CITY OF ALBUQUERQUE

Re: La Siguena
1809 San Pedro Dr. NE
Traffic Circulation Layout
Engineer's/Architect's Stamp **12-17-2018** (J18D047)

The TCL submittal received 12-17-18 is approved for Building Permit. A copy of the stamped and signed plan will be needed for each of the building permit plans. Please keep the original to be used for certification of the site for final C.O. for Transportation.

### HC SIGN

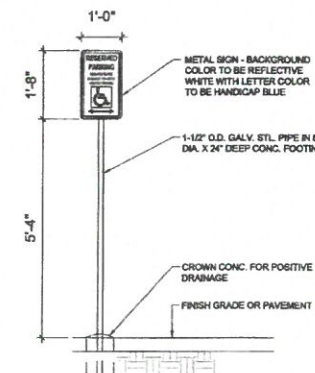
1. When requesting final CO, please make sure ADA signs reflect required language.
